10 October 2024

Allen Peterson
Precision Custom Homes

Reference: Structural Evaluation
Magnolia Hills – Lot 4

**FOUNDATION PLAN**  
Scale: 1/4" = 1'0"

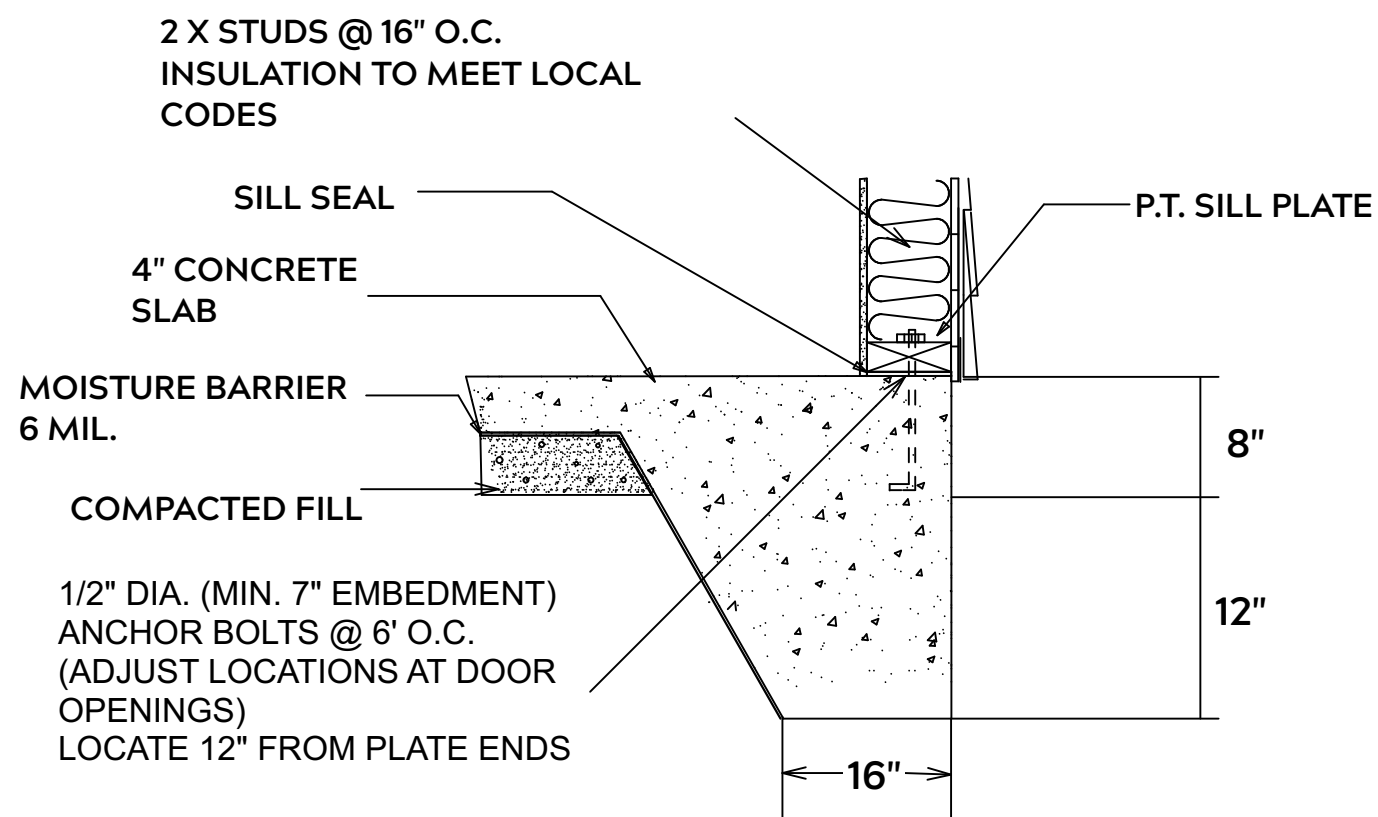
OTG Consulting, PLLC (OTG) was requested to evaluate the planned footings at the garage door and determine the required sizes. OTG was provided a copy of building plans, truss layouts, and member design report. We understand that the garage header will span approximately 16 feet 10 inches and consist of a 2-ply 1 ¾" x 20" LVL. The footing loads from the garage door header are 14,865# and 10,290#.

Based on the assumed allowable soil bearing pressure of 2,000 psf (pounds per square foot) and the above stated footing loads from the garage door header, OTG recommends that the footings on each side of the garage door header be 36" W by 36" L. The footing should be a minimum of 24 inches thick. The 28-day compressive strength for the footing concrete should be 3,000 psi. A bottom mat of #4 reinforcing steel (2- #4 bars ea way) should be placed in the bottom of the footing on rebar chairs providing a minimum of 3 inches of cover from the bottom of the footing. Contractor should also ensure a minimum cover of 1 1/2" of cover between the sides of the footing and the edges of the rebar.
